SI-16-00001 Cle Elum Roslyn School District Sign Application Analysis

Staff Planner: Dusty Pilkington

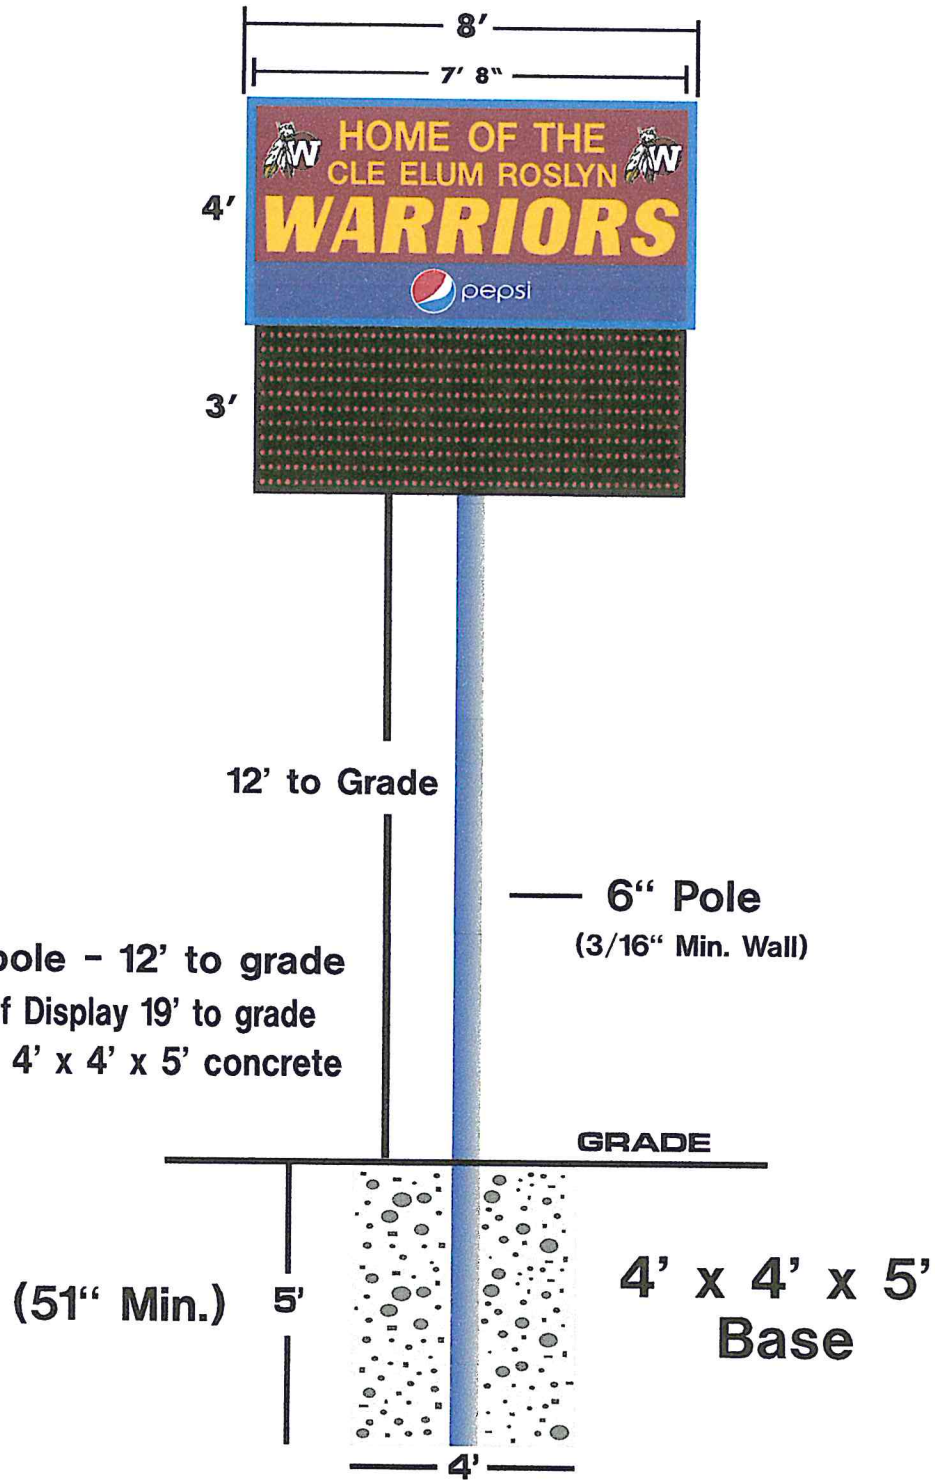
As shown in Figure 3, the proposed has a total height of 19'. The top signage is 32 ft² in area, and the electronic display is 30.64 ft². The combined area is 62.64 ft².
